From:
To: [DCAdmin](#)
Cc: [Nick Hirst](#)
Subject: Planning Application 2020/93954 - Inaccurate Plan
Date: 19 January 2023 10:41:52
Attachments: [inaccurate plan.pdf](#)

Please find attached a personal comment concerning the revised housing development off Lingards Road.

SITE AT LINGARDS ROAD - PROPOSED HOUSING			
CLIENT - S.B. HOMES LIMITED			
William Best RIBA		SITE SECTIONS: H, J, K, L, M, N, P & Q	
The Chapel House, 22, Pole Gate, Sarnammonden, West Yorkshire, HD3 3FW. Tel 01484 845886 Mob 07828 481144		SCALE	DATE
		1:200	04-03-2020
		WB	2019-572-15 G

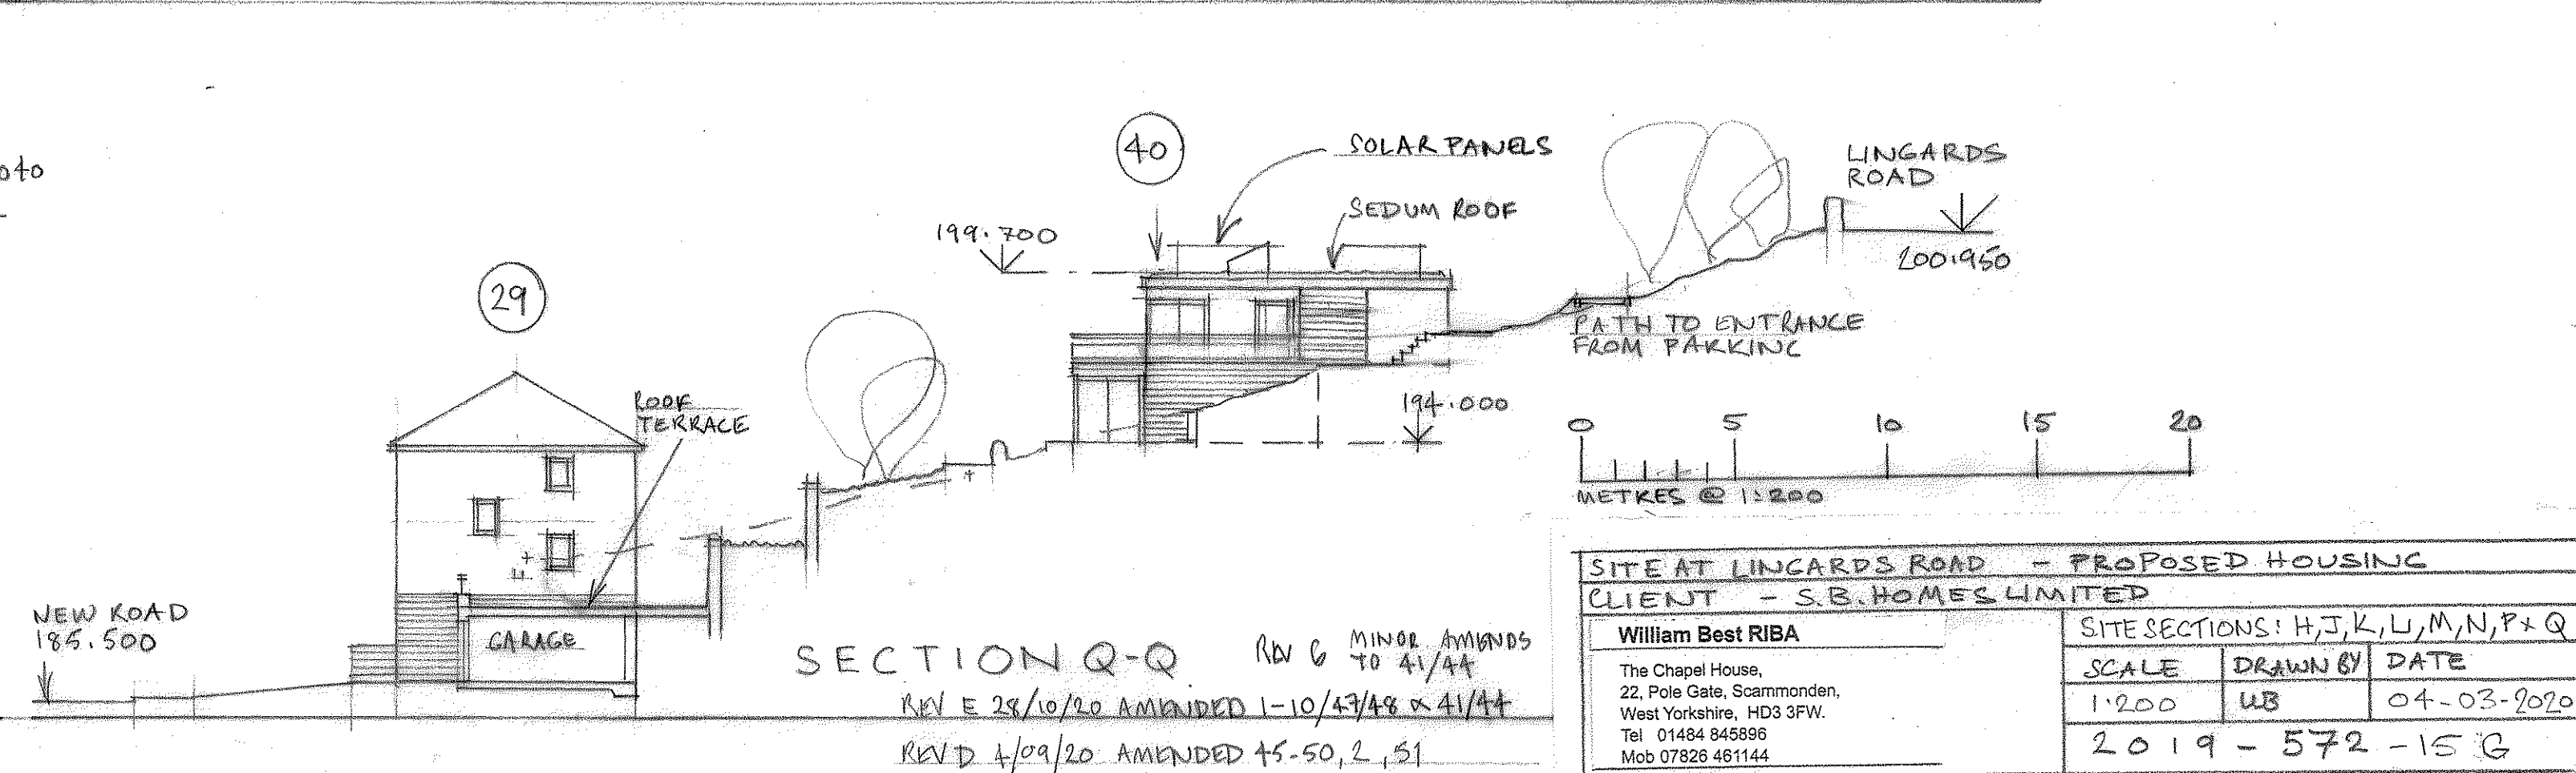
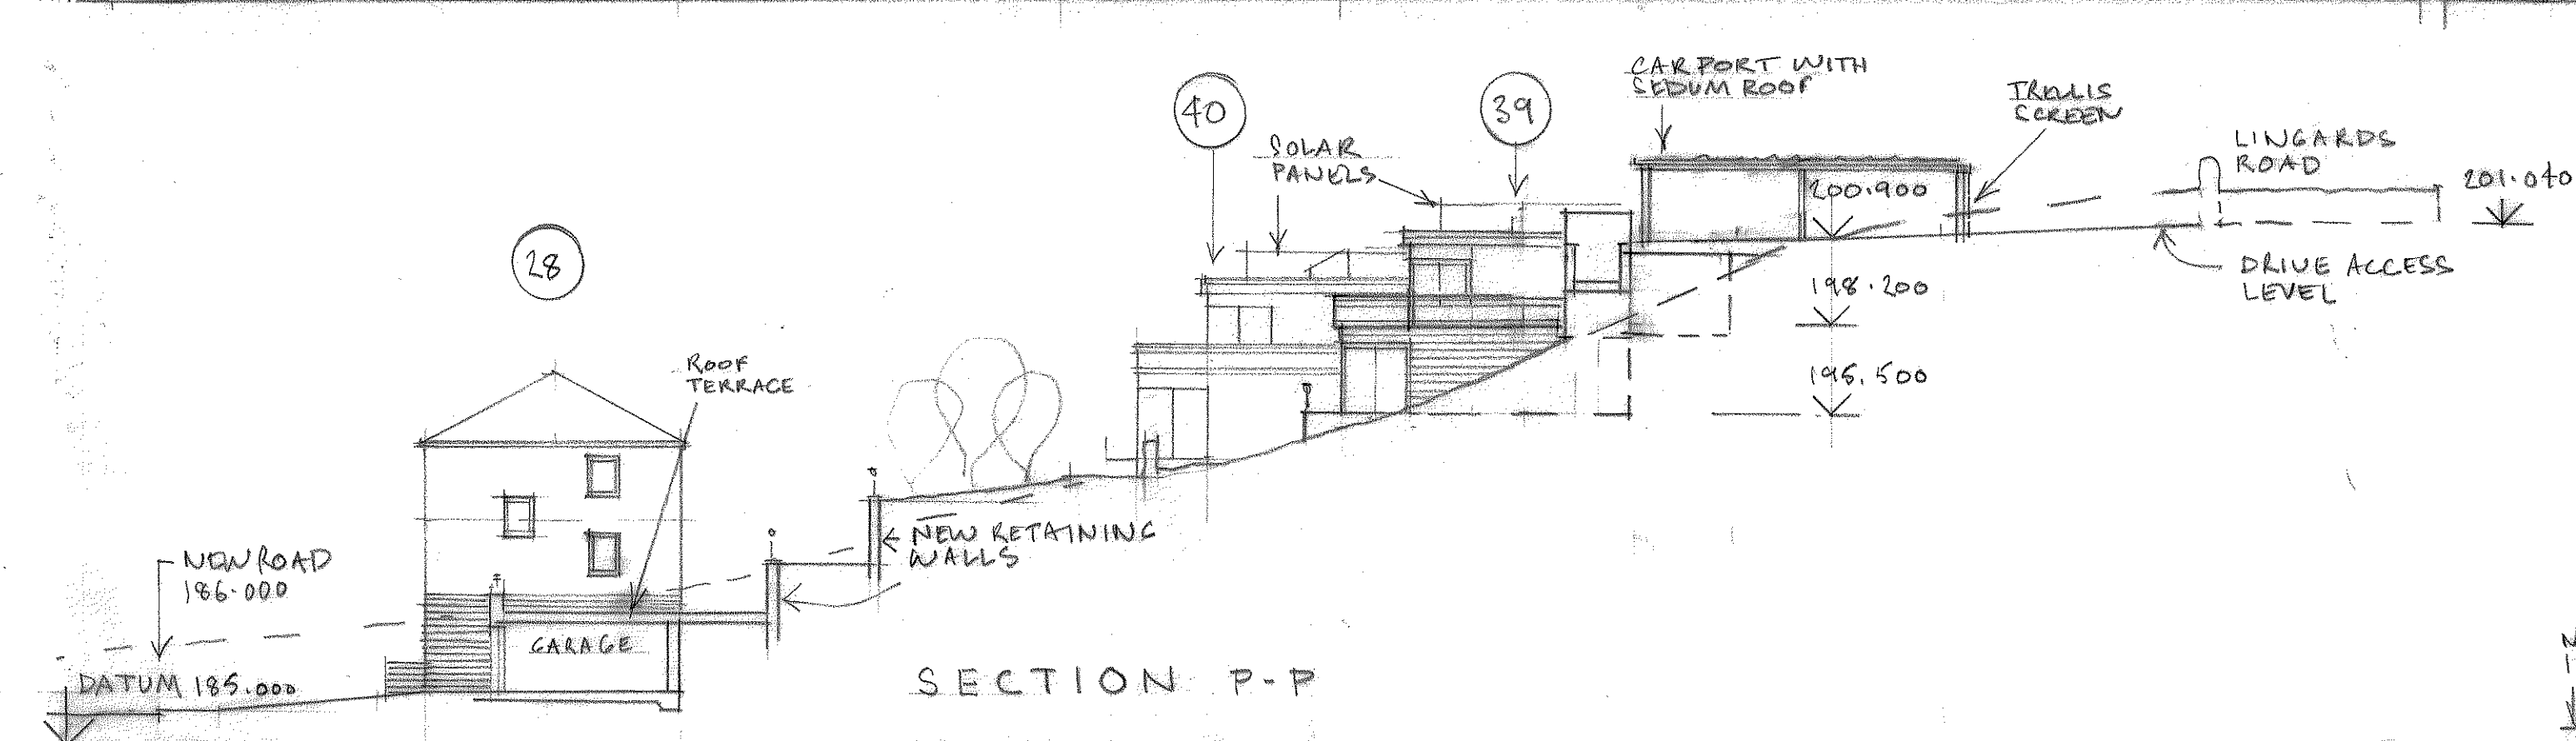
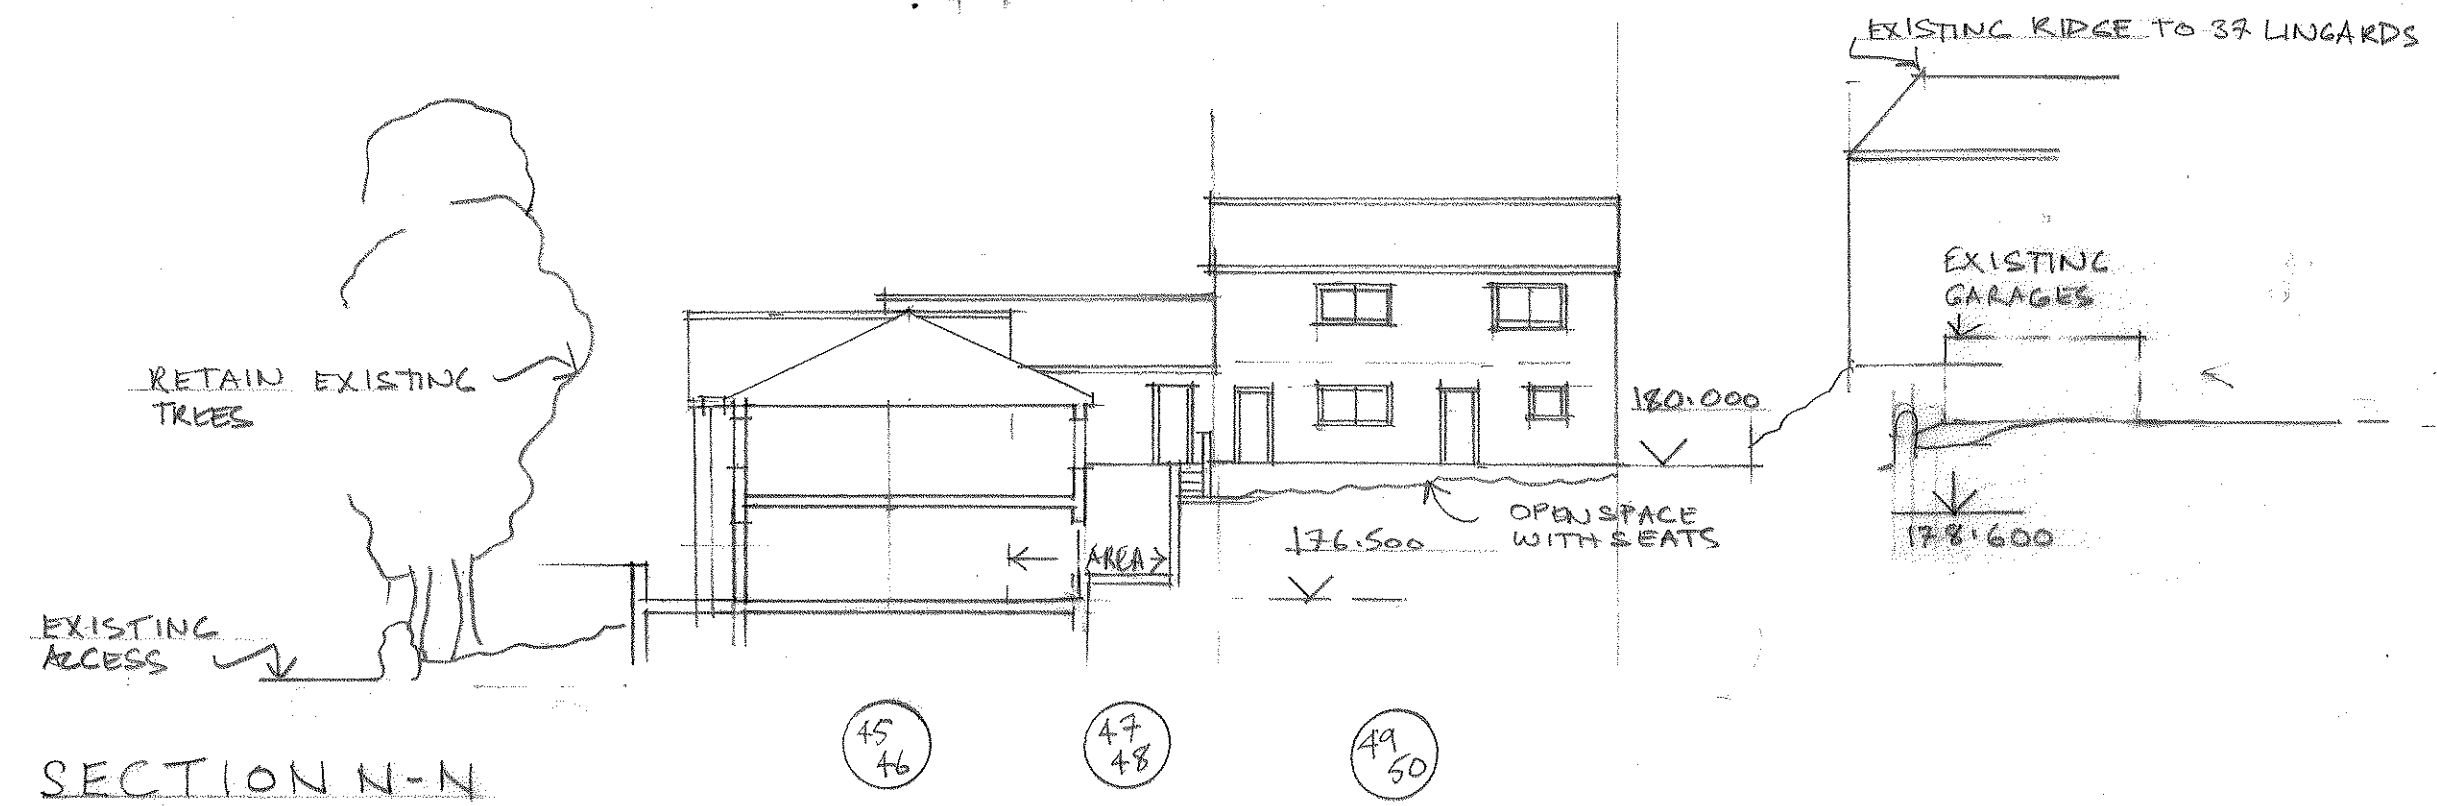
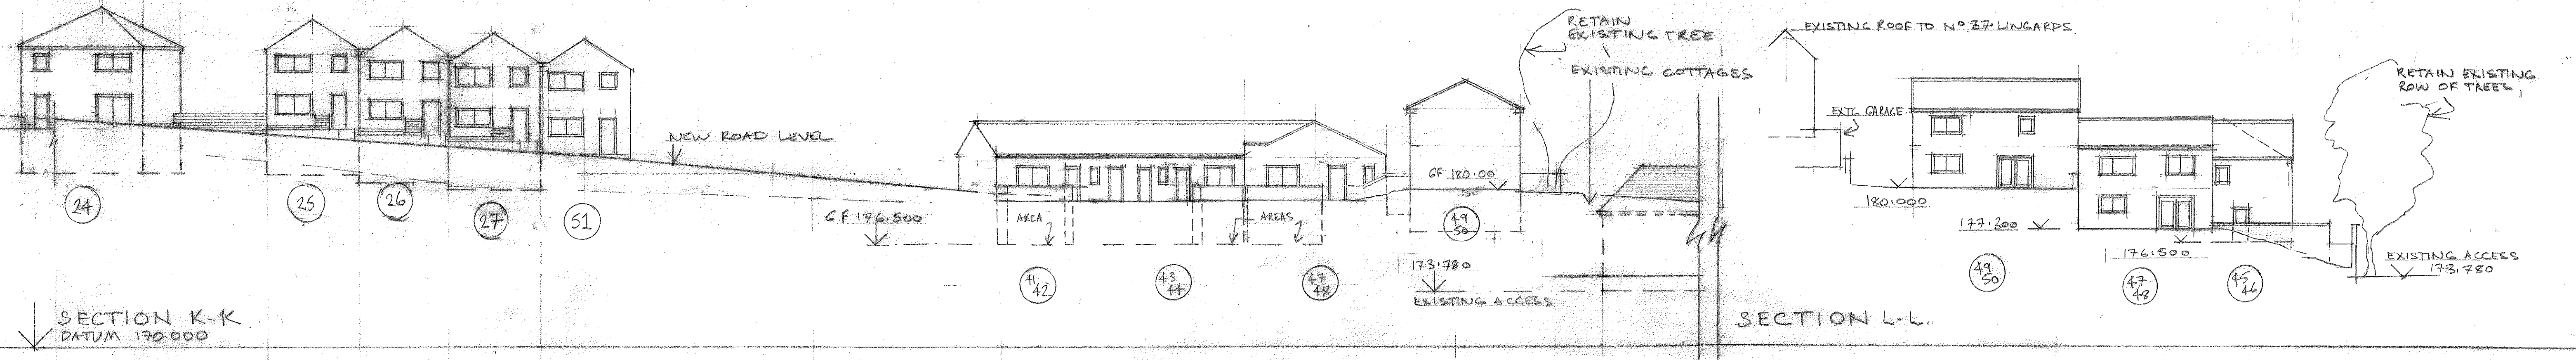
The latest issue relates to the alleged existing width of Lingards Road.

Outside no.82, the width is said to be 5.61m:
see image right.

This image is an extract from the applicant's plans.

As measured by the owner of no.82, the road width was found to be only 5.1m.

This suggests the plan is almost 10% inaccurate.

Ironically and infuriatingly, that 0.5m appears to be the difference between the plan and reality.

That's because this plan does not include the 0.5m increase proposed, which would take the road width to 6m.

If a wildly inaccurate map is used by planners to make decisions, poor/bad decisions could easily result.

If the applicant cannot produce accurate maps, how is anyone able to trust their measurements in terms of what would be built, where and to what size?
